**Notice of Exhibition of application for Redevelopment of Bankstown North Public School - SSD 10290**

**Rajeev Maini**  
 Senior Team Leader  
 South Assessments  
 Heritage NSW  
 Department of Premier and Cabinet  
**As Delegate of the Heritage Council of NSW**  
 12 November 2020

Figure 56 Proposed east elevation of Block A and Block 4

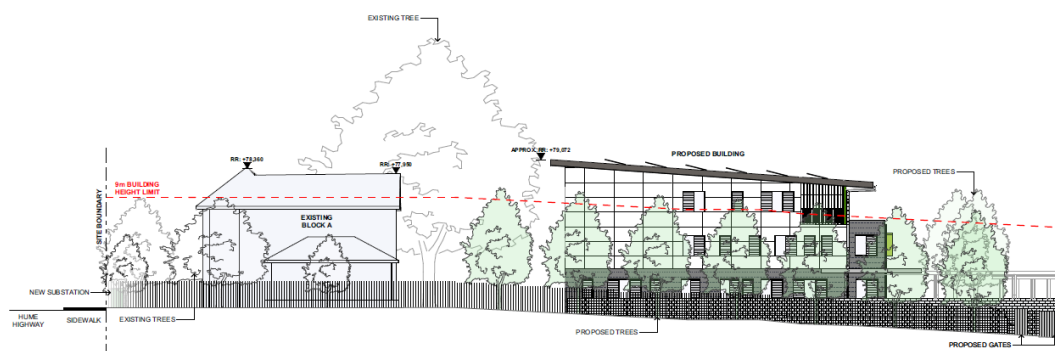
- The retention of Block A and the proposed 38m setback from the new school buildings is considered a positive heritage impact.
- It is recommended that the Construction Management Plan include site induction for trades persons outlining the significance of building Block A as well as a set of protection measures for Block A during construction.
